**TOWN AND COUNTRY PLANNING SCOTLAND ACT 1997  
PROPOSED VESTIBULE EXTENSION AND INTERNAL ALTERATIONS TO  
FORM GROUND FLOOR SHOWER ROOM. AT 42 ORCHARD BRAE AVENUE,  
EDINBURGH, EH4 2HN  
REFERENCE NUMBER: 23/07344/FUL**

**INCOMPLETE APPLICATION**

**Planning Application No: 23/07344/FUL  
Scottish Government No: 100655083-001**

DRAWING
SURVEY PLAN
as existing

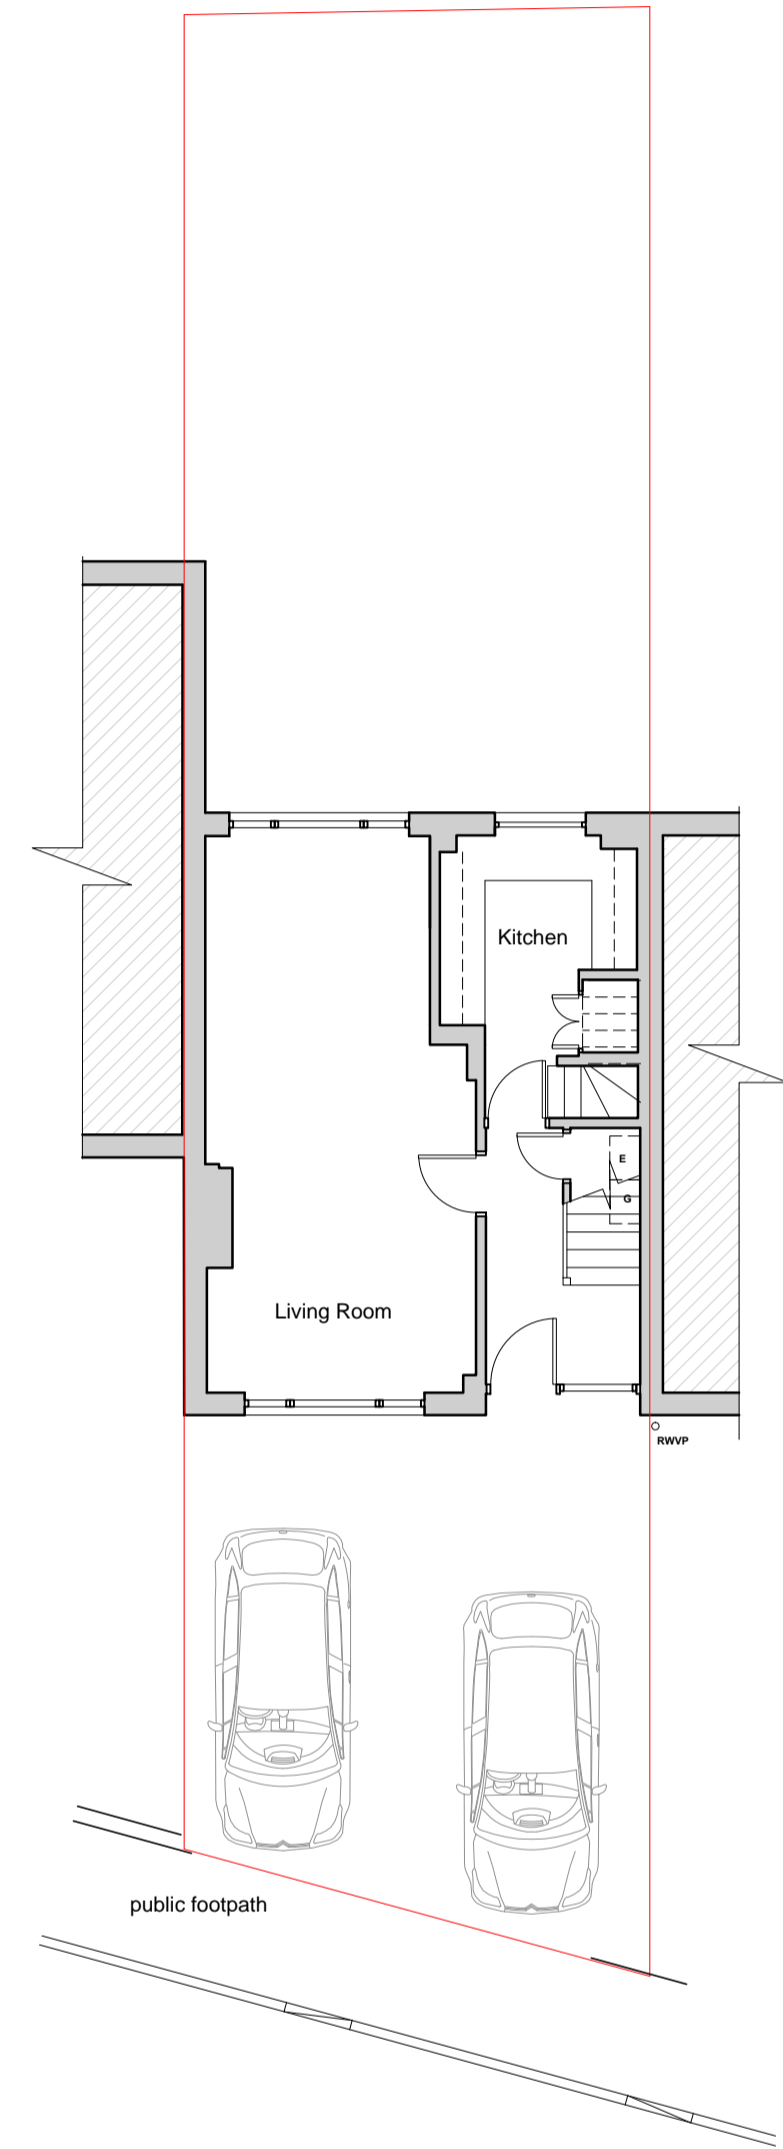
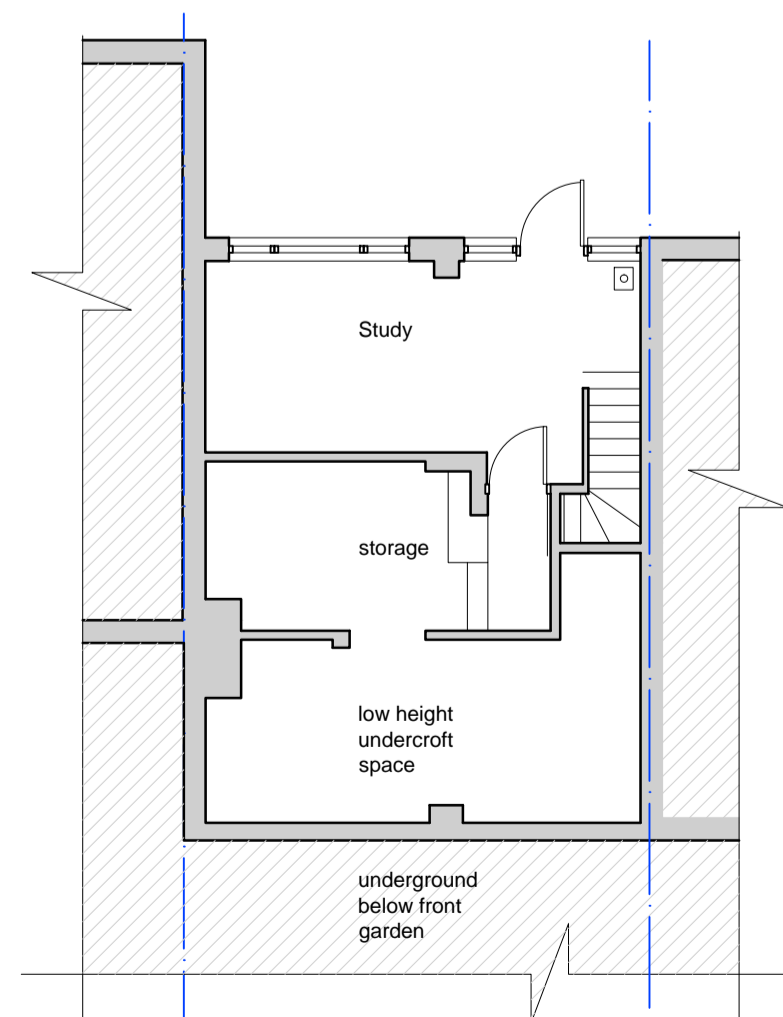
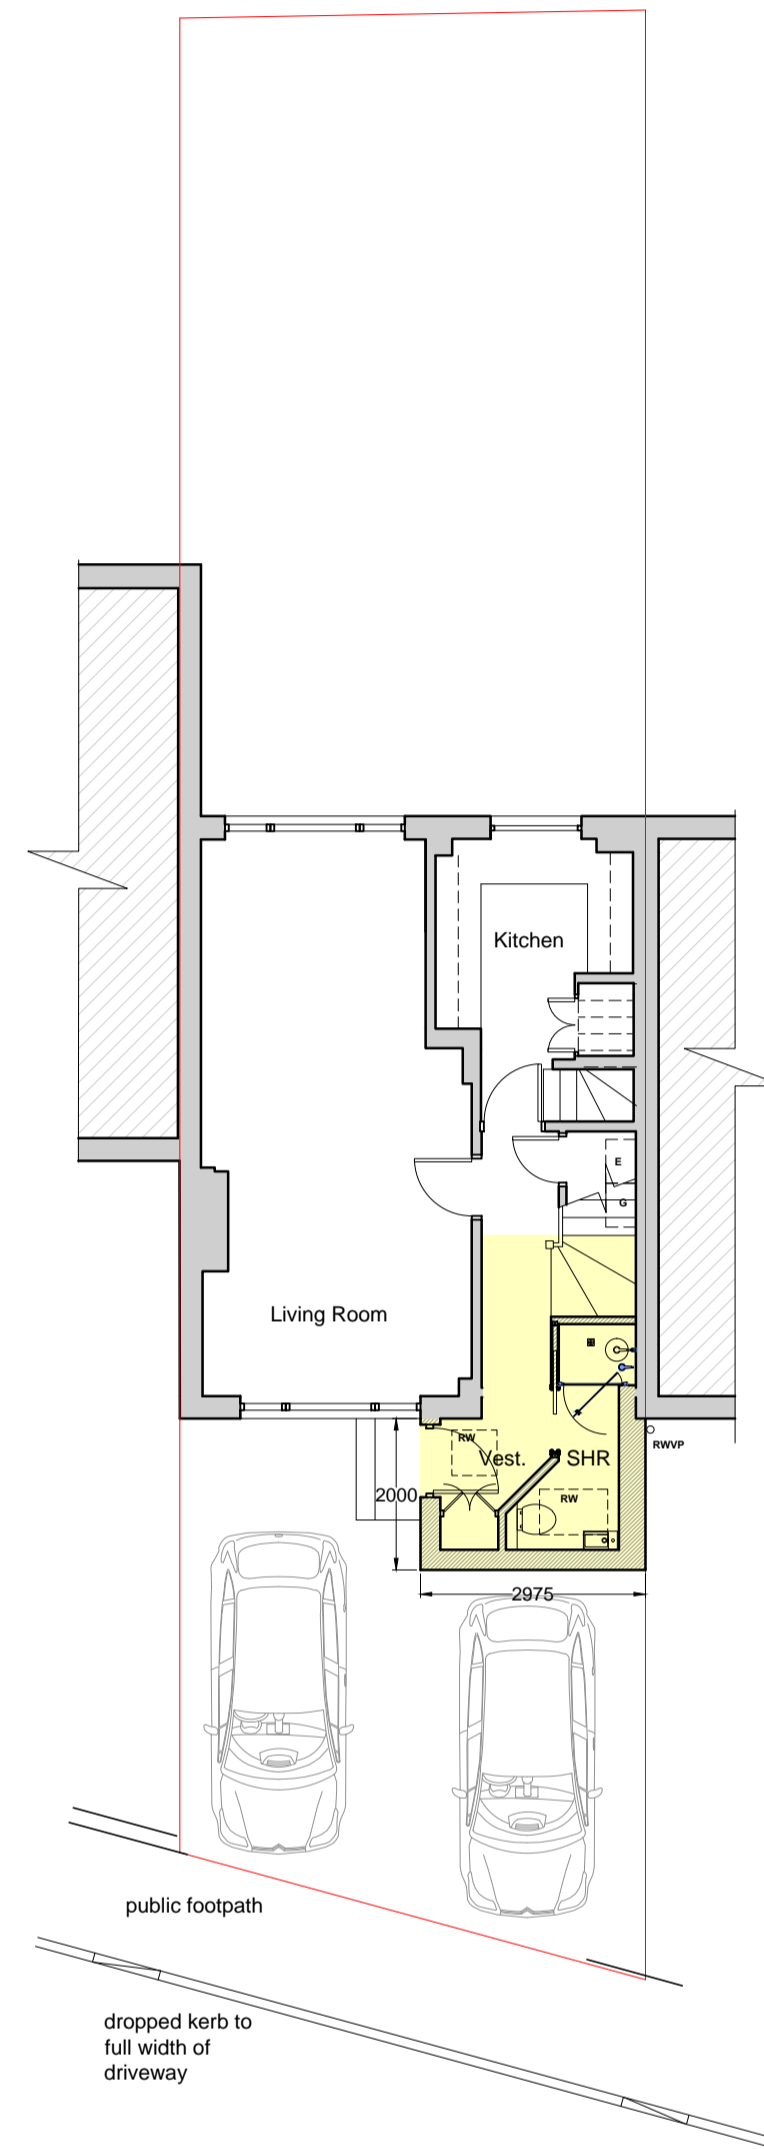
- 01. Location plan required - at scale 1:1250 or 1:2500 for larger sites. The application site boundary must be accurately outlined in RED and any other surrounding land under the same ownership as the application site must be outlined in BLUE. Please refer to Appendix 2 of the validation guidance below for full requirements.**
- 02. Site plan required - at scale 1:100, 1:200 or 1:500. The application site**

boundary must be outlined in red and any surrounding land owned by the applicant outlined in blue. The footprint profile of the existing and proposed buildings must be shown. The proposed work must be in colour. Please refer to Appendix 2 of the validation guidance below for full requirements.
